KIRKLEES METROPOLITAN COUNCIL INVESTMENT & REGENERATION SERVICE

DELEGATED DECISION TO DETERMINE APPLICATIONS FOR CONSENT, AGREEMENT OR APPROVAL REQUIRED BY CONDITION

Reference No:	2022/44/92236/E
Site Address:	Field House, 15 Wellington Street, Dewsbury, WF13 1BQ
Description:	Discharge of conditions 3 (windows), 4 (additional storey), 5 (materials), 6 (residential waste), 7 (A3 use waste), 9 (swift nesting), 14 (ventilation), 15 (noise assessment) and 19 (air quality) of previous permission 2019/92962 for erection of additional storey and conversion of building to provide 23 self-contained apartments and A3 use in basement and part of ground floor (Listed Building within a Conservation Area)
Recommending Officer:	Victor Grayson

Third Officer Report

01 Site Refuse Strategy Plan
Scale: 1:100

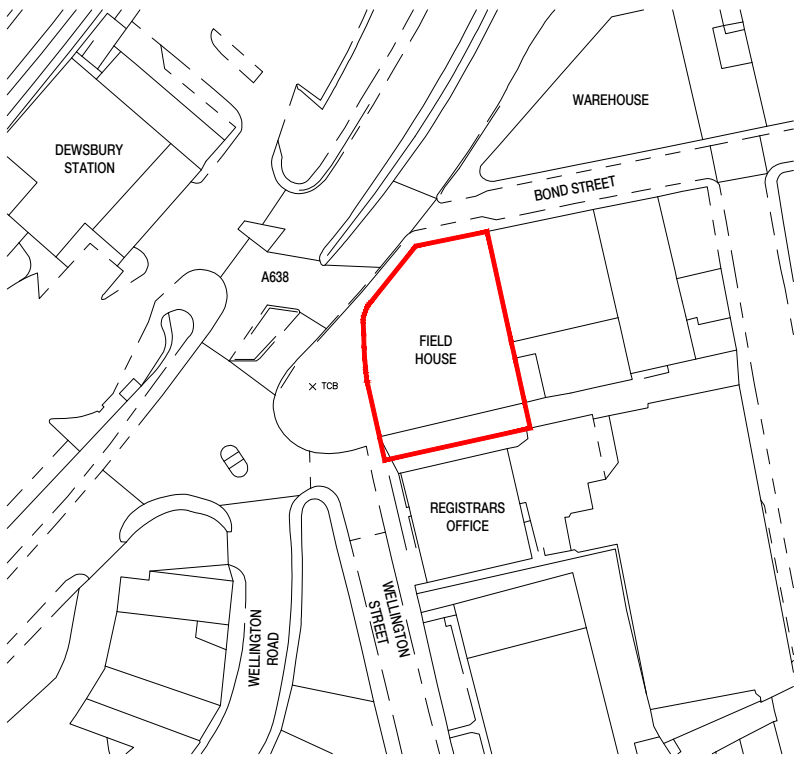
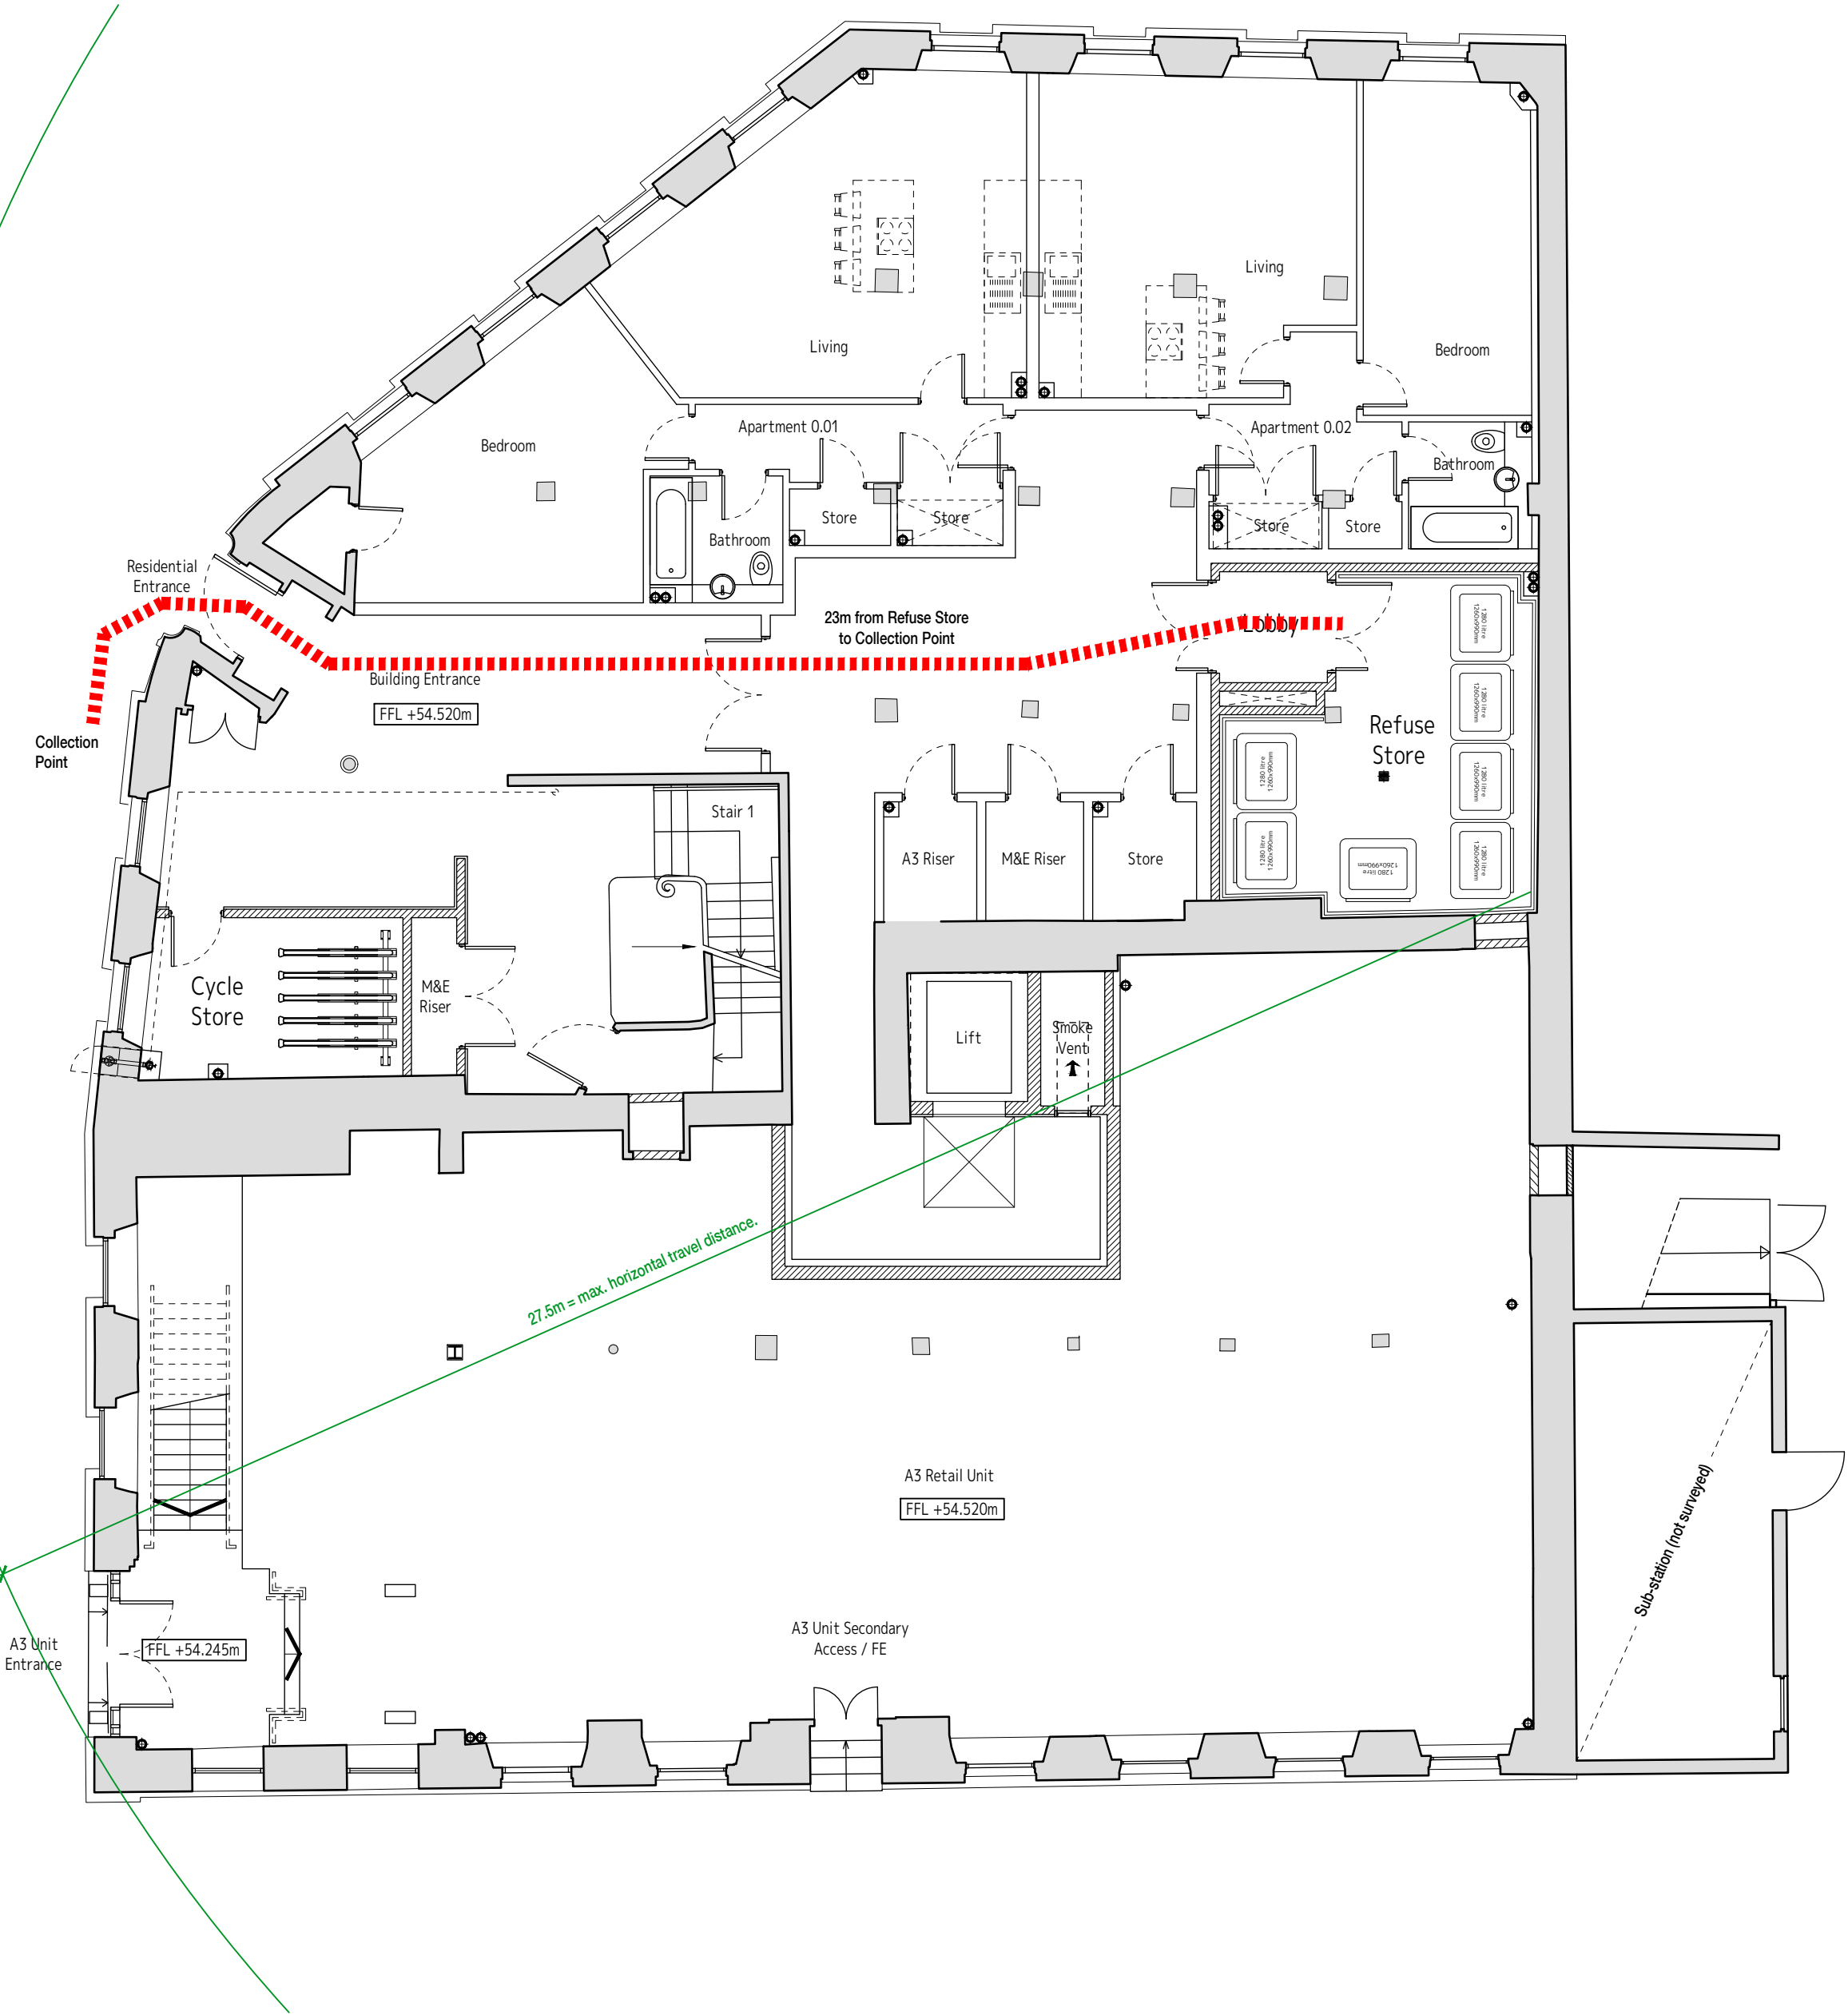
Despite some changes the proposals do not really address the waste issues identified by Carol Oakden in her response to the 2019 planning application e.g. location of store with access through lobby to main entrance and then no close location for access of an RCV.

1 Elevation 1
Scale: 1:100

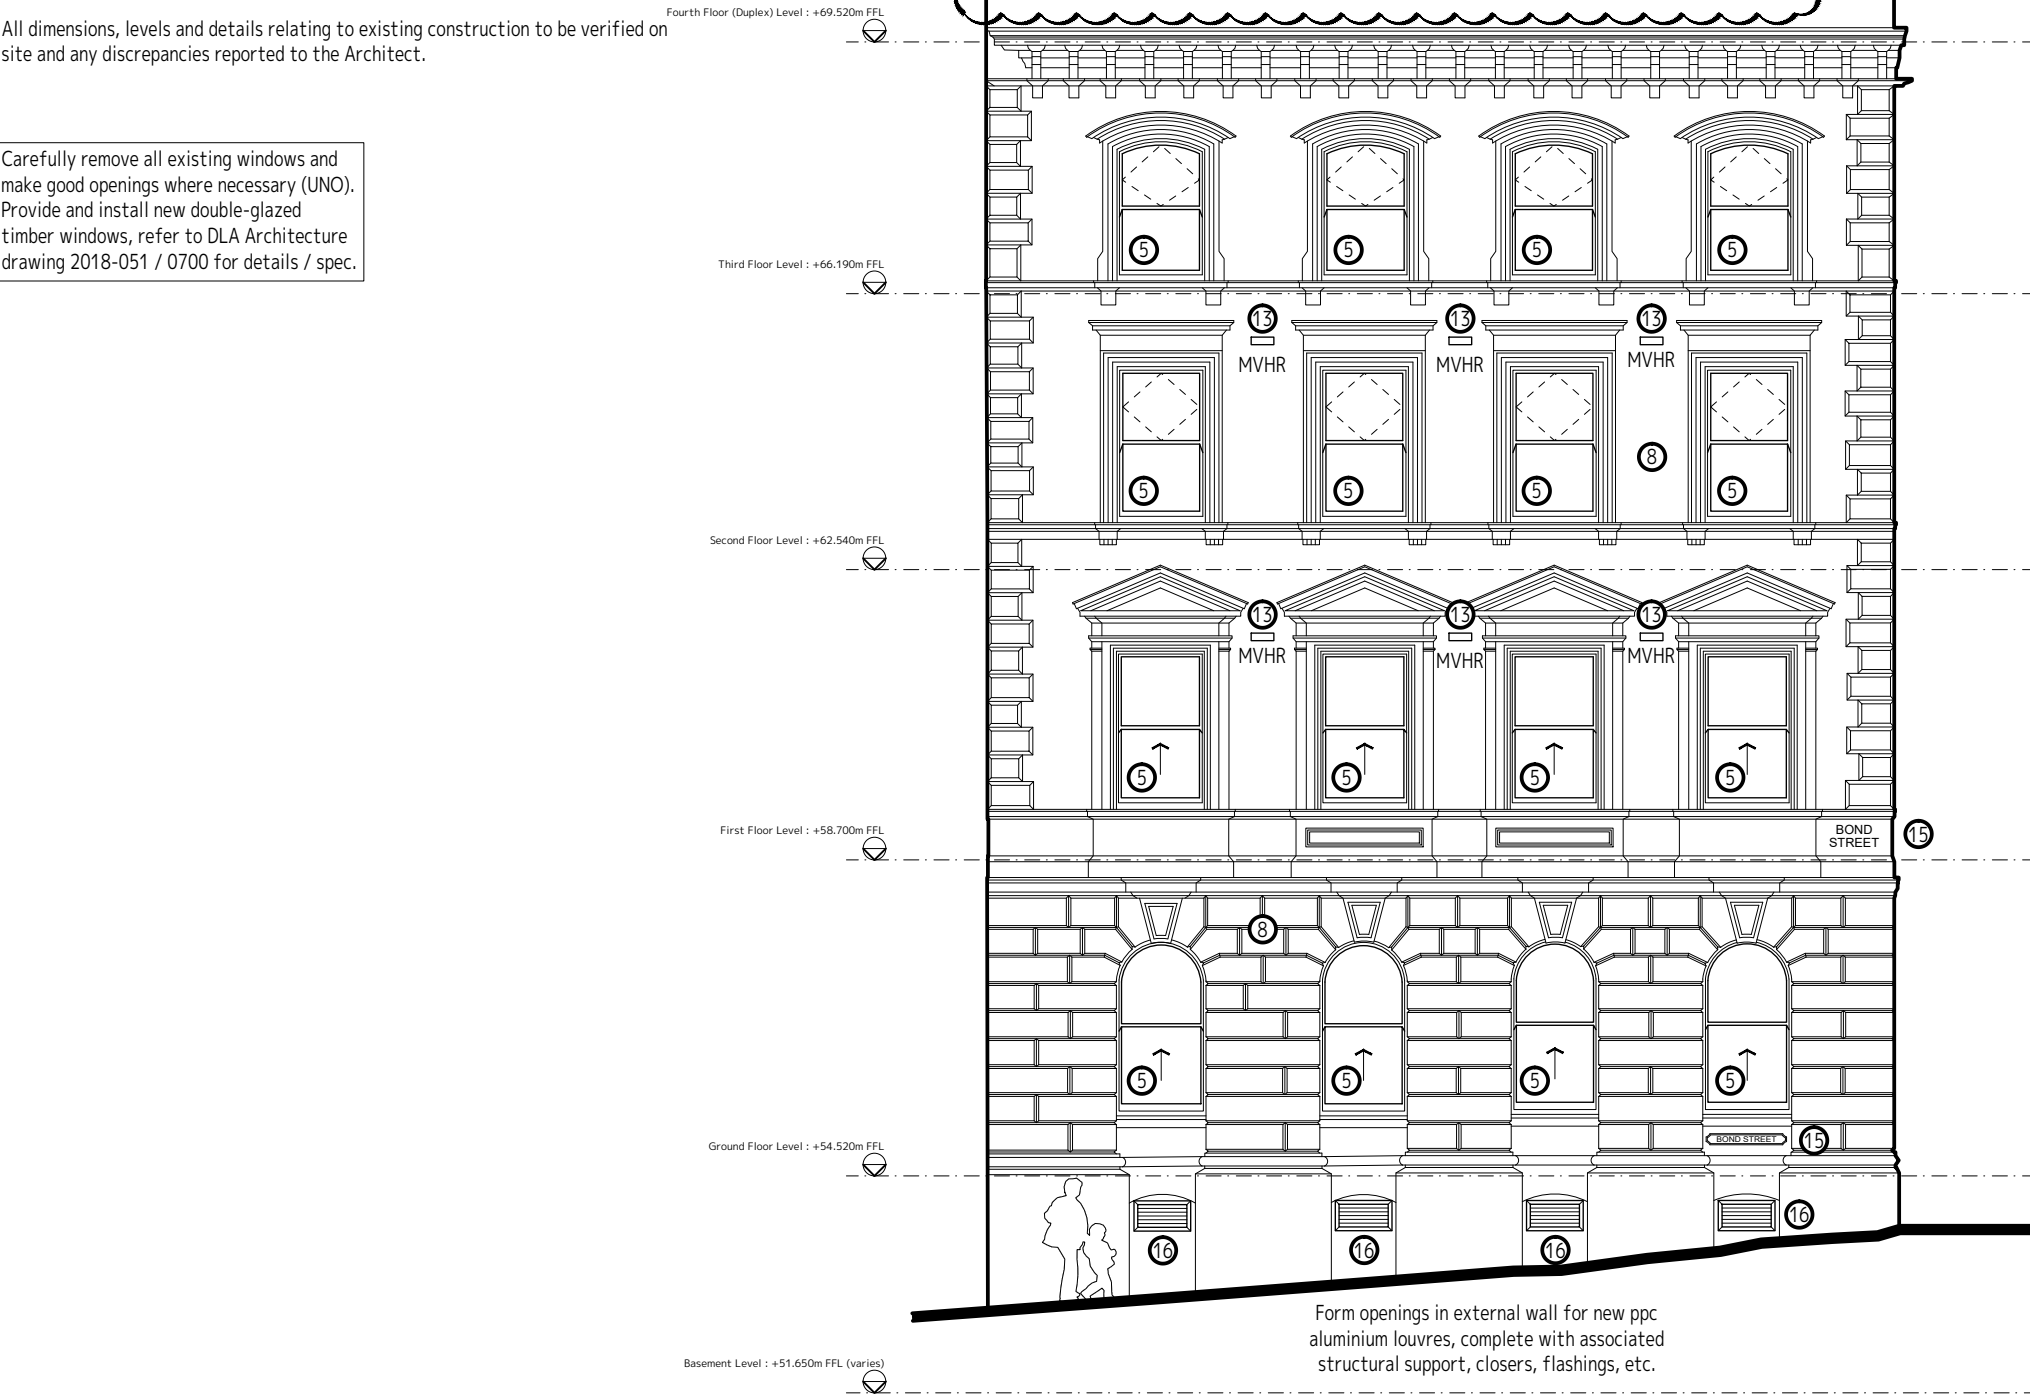
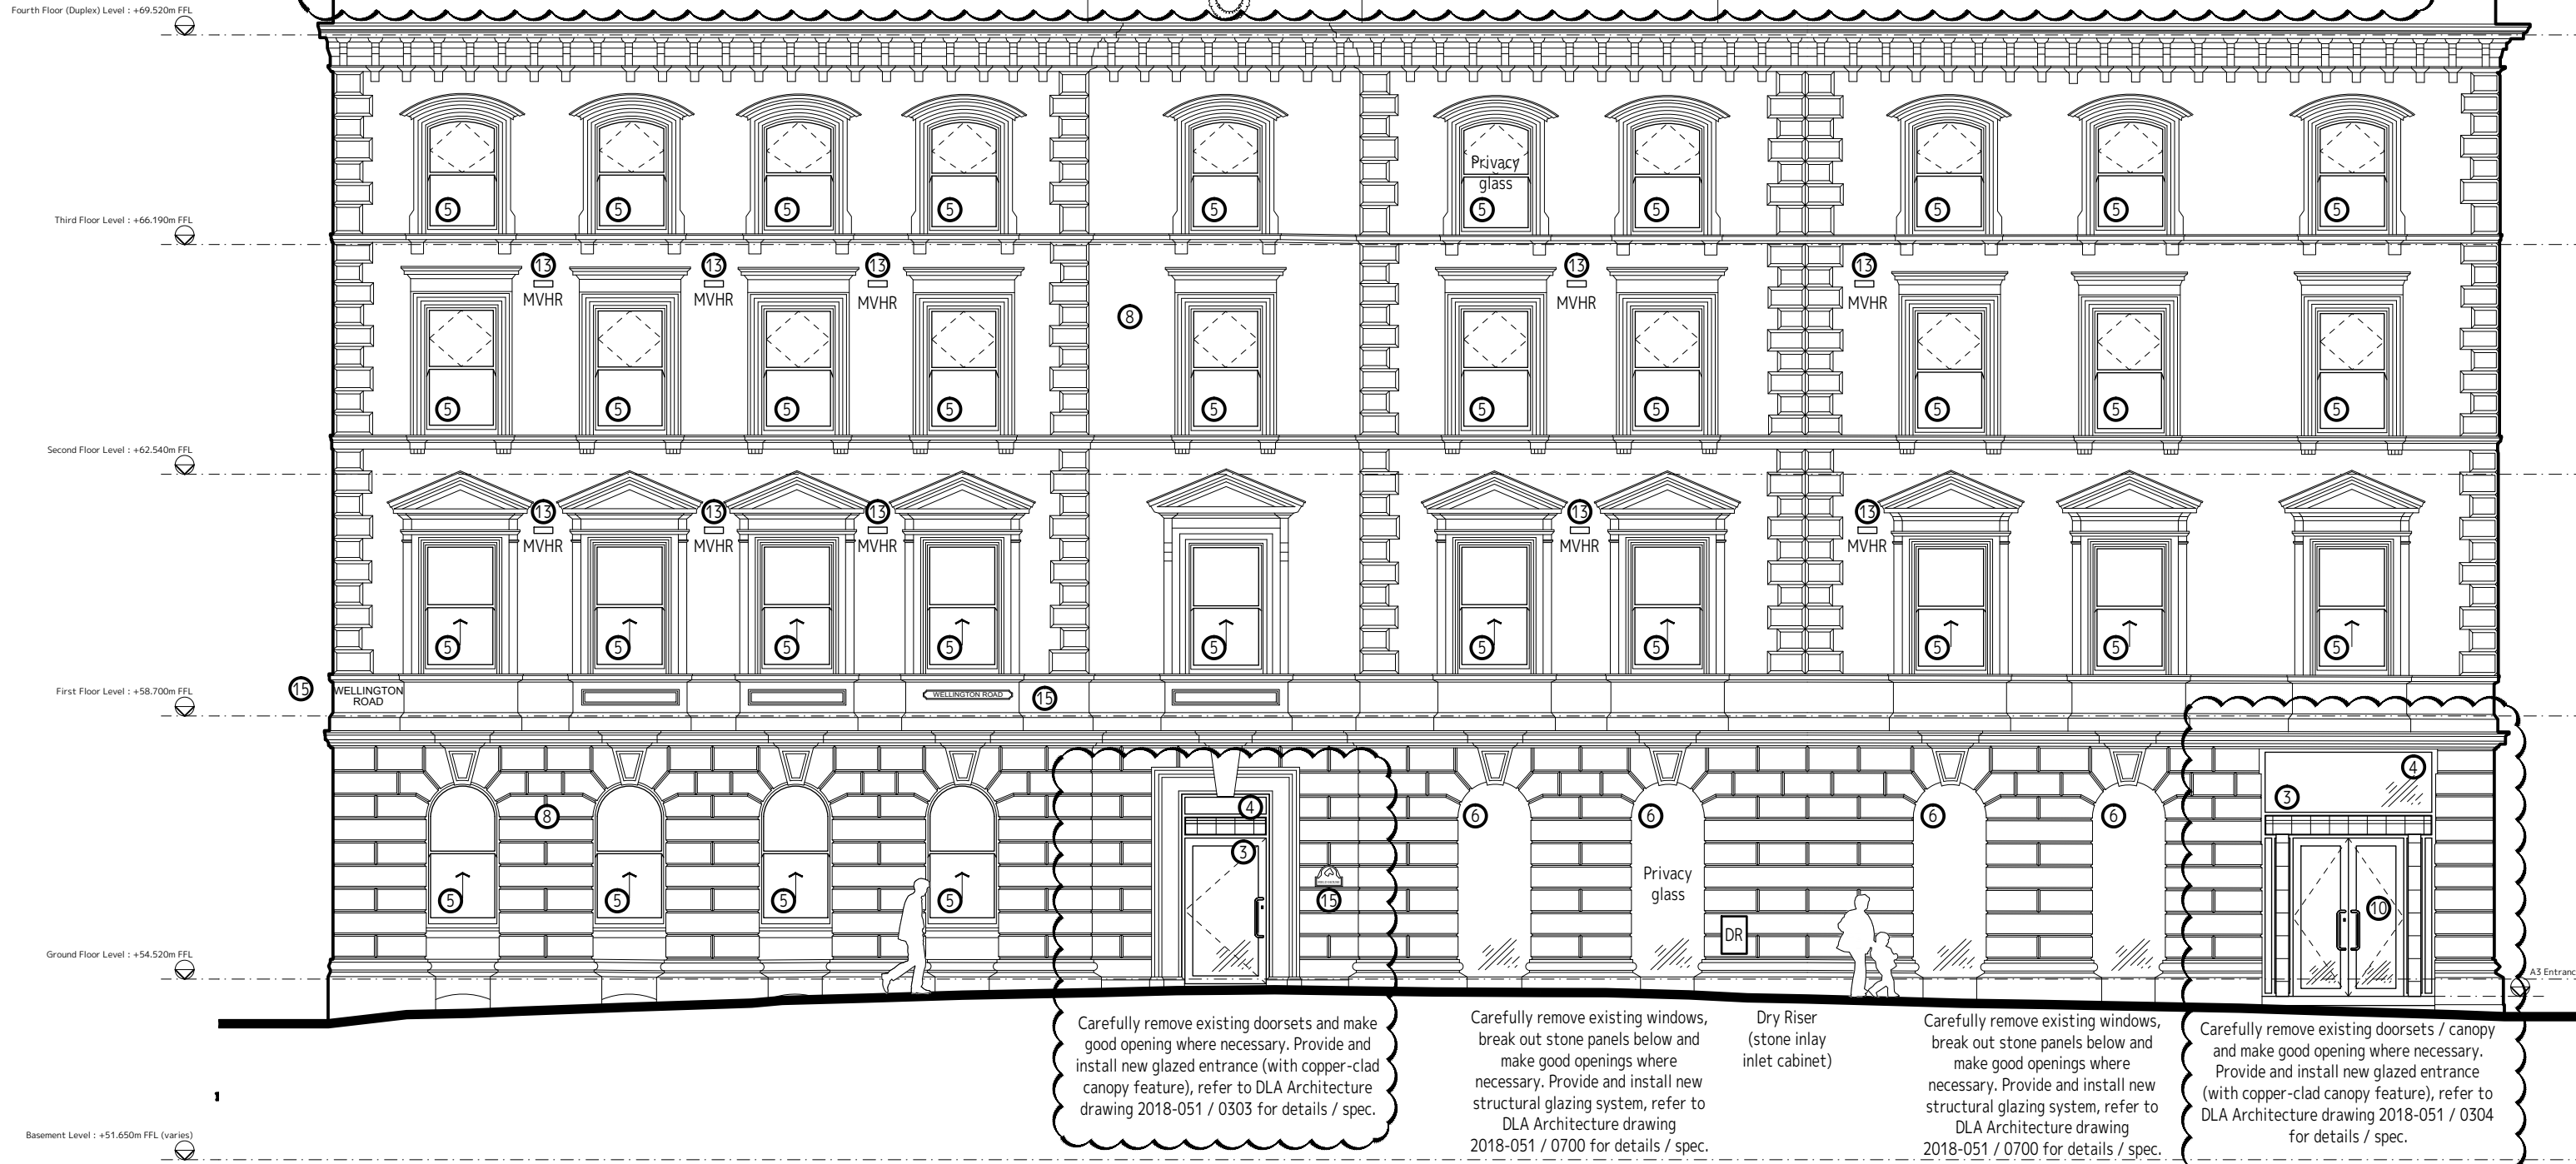
As proposed this additional storey could appear rather incongruous to the design/materials of the listed building and surrounding conservation area.

The window size looks reasonable but as [the case officer has] pointed out they are rather different otherwise. I am also uncertain about the complete lack of window surrounds when this is a prominent feature of the building, and the use of zinc cladding as the primary material on the facing pitches of the roof. Tiled materials/appearance for the face of the roof would probably be a better fit with the area.

Officers also requested amendments to the proposed replacement windows, including the deletion of pivot-opening windows at second and third floor, amendments to numbers of panes and to glazing bars, and the replacement of solid panels above the fourth floor windows with fixed clear-glazed panels. These amendments were made by the applicant.

During the life of this Discharge of Conditions application, much of the discussion with the applicant team has related to the proposed colour of the new windows. A dark grey (RAL 7021) is proposed for all windows with frames.

Officers' concerns related to context. Field House sits in the centre of a group of historic buildings (which have a shared character, and are the first thing seen when leaving the railway station opposite), all of which have white windows.

In comments dated 26/06/2023, KC Conservation and Design raised no objection to the design of the proposed additional storey, including in relation to its zinc standing seam cladding (although hanging slates would have been preferred), flush pivot windows to elevations 1, 2 and 3, and inset sliding doors on the less visible elevation 4. As detailed earlier in this report, a concern regarding the solid panels previously proposed above the fourth floor windows has been addressed by the applicant.

However, in the applicant team's most recent representation (an email dated 20/03/2024) reference was made to nearby buildings at Wellington Street and Whitehall Way, and to the applicant's desire to ensure the building's windows complement the additional storey and the entrance to the proposed A3 use. These points are valid. It is also noted that there is some evidence of dark-framed windows once existing at Field House. Finally, it is noted that the building's new timber windows would be painted, and could be repainted in future years should the current trend towards dark grey be reassessed. Taking all these considerations into account, while white or cream windows would still be preferable for this building (given its context, and as maintained by KC Conservation and Design), dark grey can be accepted.
